**Re: NOVA Entrance (Formerly Schott Solar)
5201 Hawking Dr. SE
Traffic Circulation Layout
Engineer's/Architect's Stamp dated 3-5-15 (Q16-DA5000)**

Re: Schott Solar Phase 1 Traffic Circulation Layout Certification

Re: Schott Solar Phase 1 Grading and Drainage Plan

Re: Schott Solar Phase 1 Grading and Drainage Plan Comments

DRAINAGE MANAGEMENT PLAN

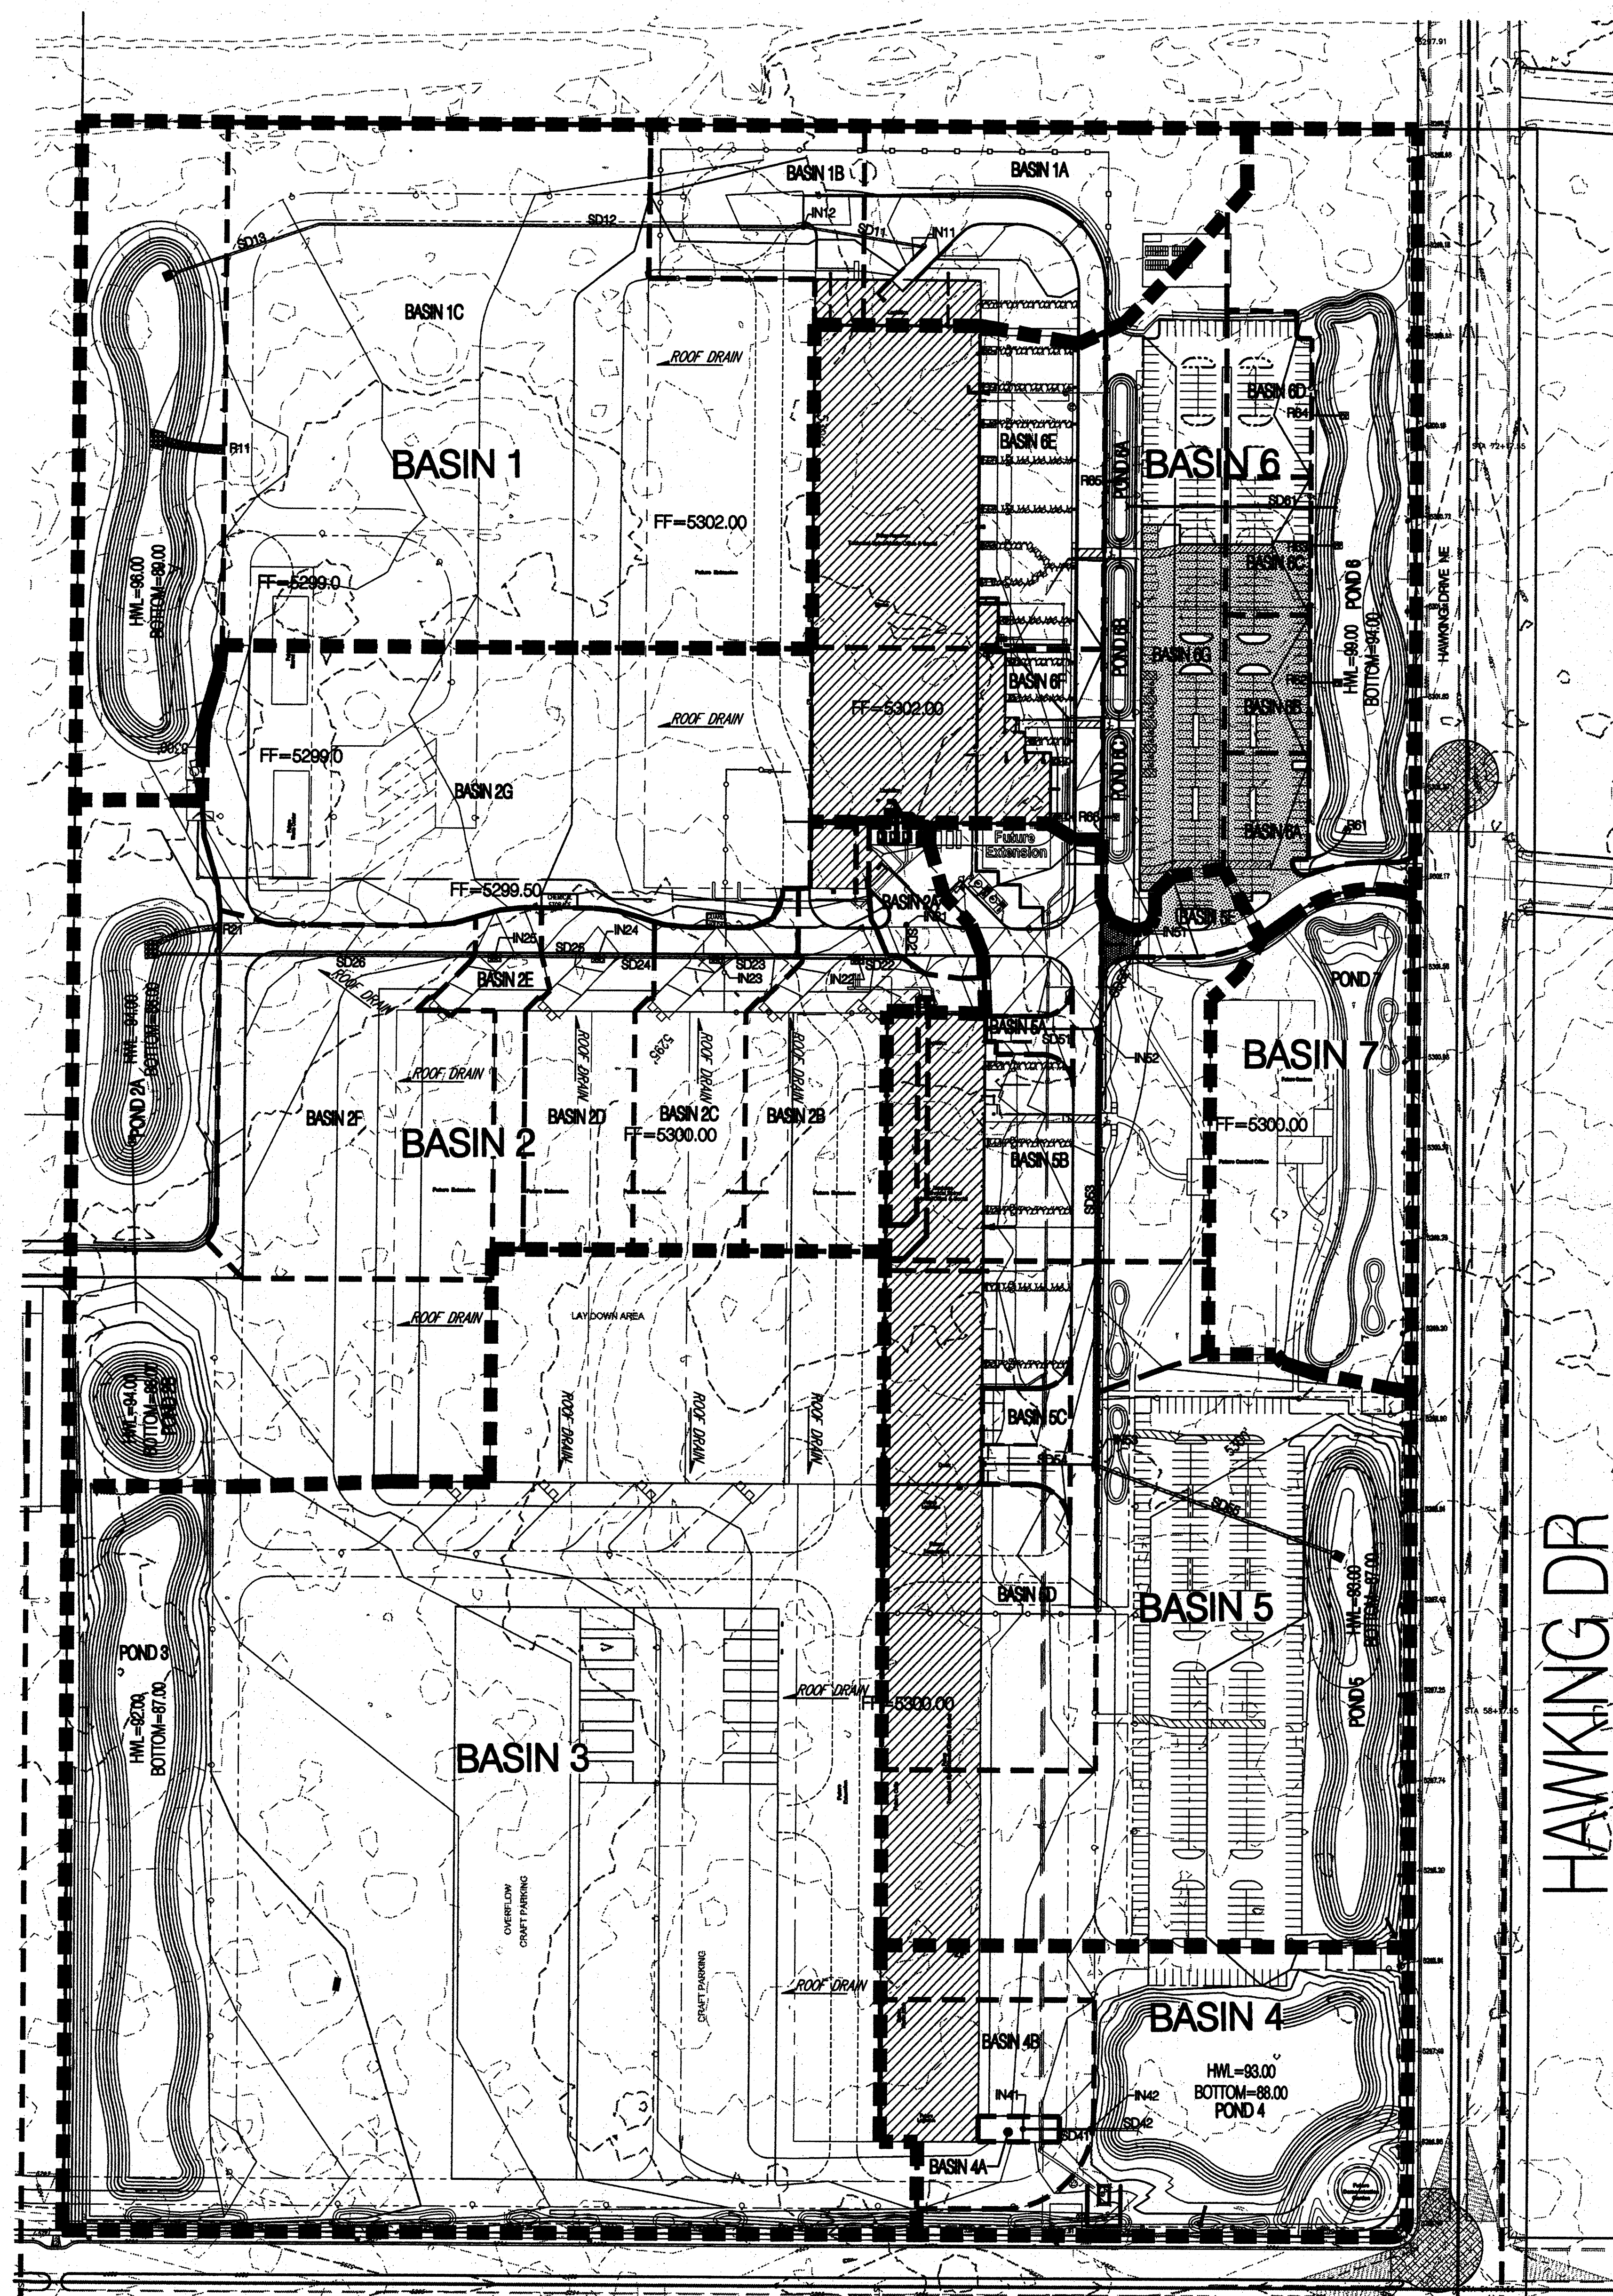
In the inlet table in sheet DMP-Overall, Basin 1 has two inlets not just the one listed.

2 RIP RAP BLANKET DETAIL
N.T.S.

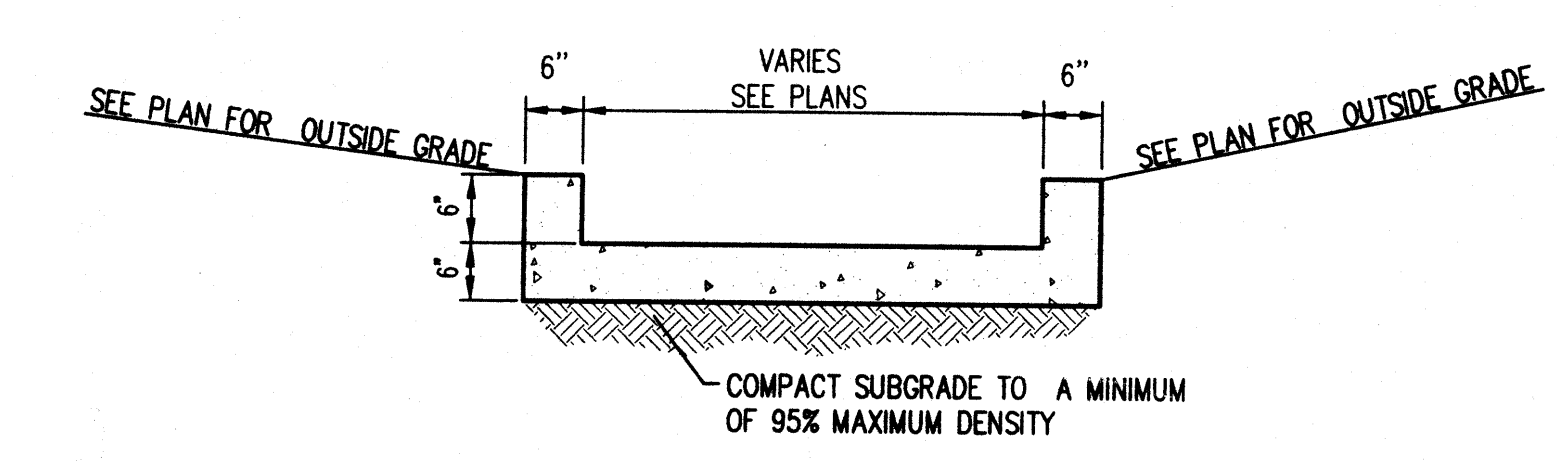
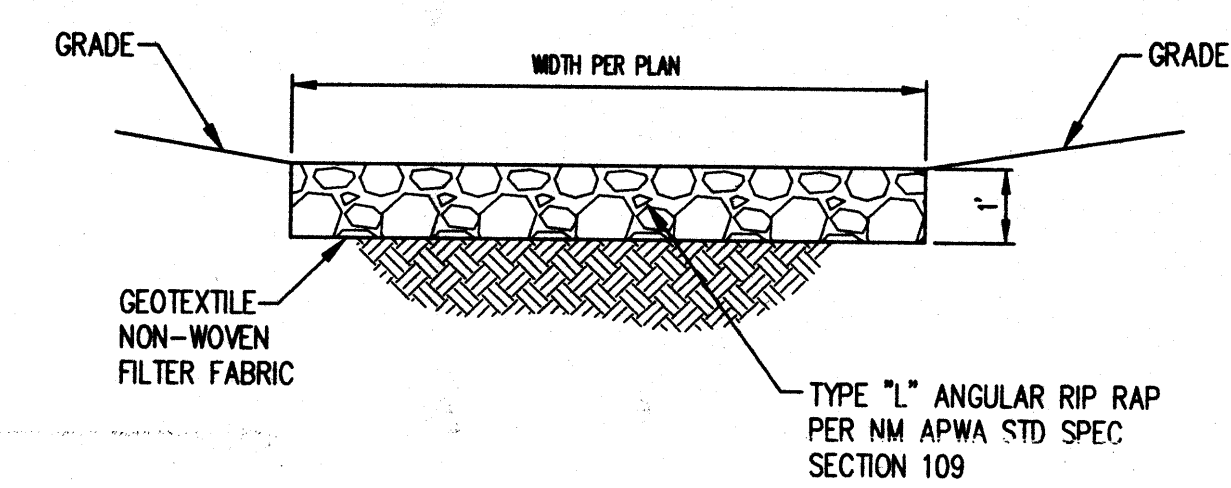
102:
Detail 2 has an "x" for the depth of rip-rap.

JOB NO.	366450	REV. NO.	
FILENAME		DWG. NO.	GN-CD-101
SCALE	1"=30'

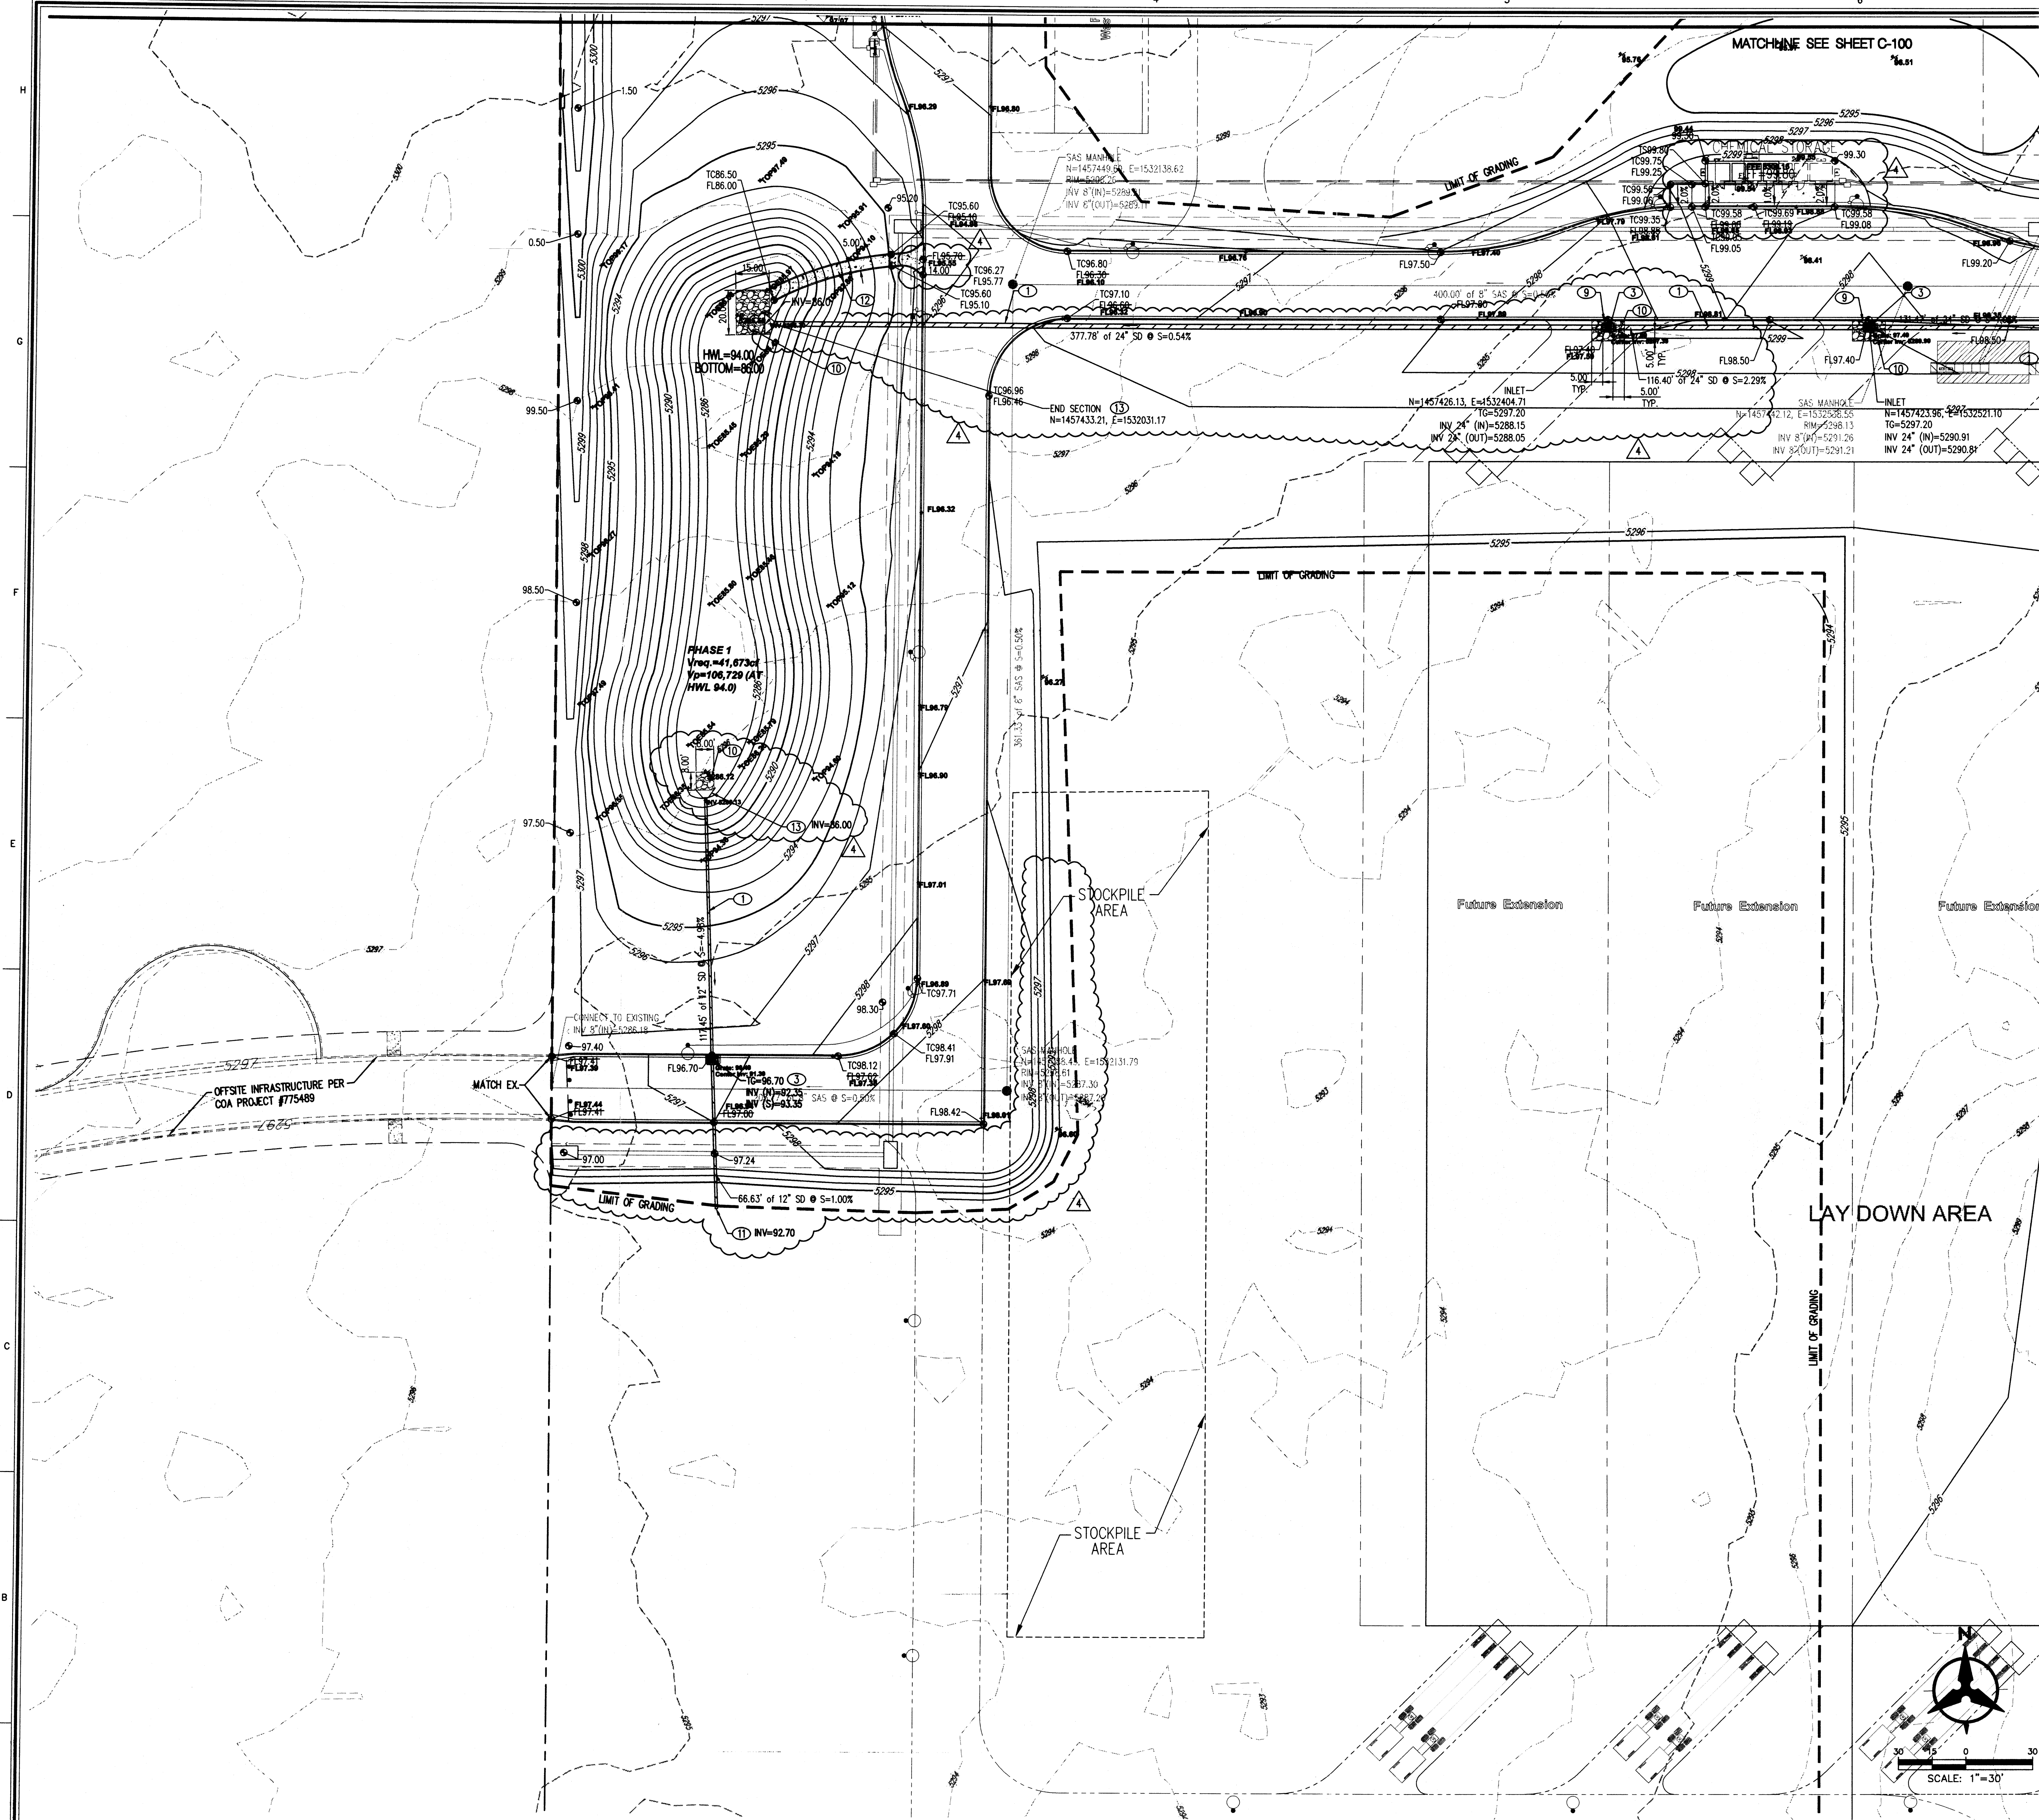
101:
There is a Note 5 on the furthest north rip rap cobble swale. Why aren't you using a sidewalk culvert like the other ones?

There is a Note 6 at the end of the rundown in the furthest north little pond. I figure you don't want a cmp end section on a rundown.

Do you want the "12'" note near a Note 6. Seems out of place.

Provide a pond hydrograph for the little ponds east of the building. If they over-top, the water is heading south.

- ✓ • There is a Note 5 on the furthest north rip rap cobble swale. Why aren't you using a sidewalk culvert like the other ones?
The sidewalk does not extend this far north.
- ✓ • There is a Note 6 at the end of the rundown in the furthest north little pond. I figure you don't want a cmp end section on a rundown.
This has been changed to Note 10, Rip Rap Blanket.
- ✓ • Do you want the "12"" note near a Note 6. Seems out of place.
Yes, this refers to a 12" end section.
- ✓ • Provide a pond hydrograph for the little ponds east of the building. If they over-top, the water is heading south.
This situation has been analyzed and revised. The pipe draining the small ponds has been resized to an 18". The AHYMO analysis is attached.
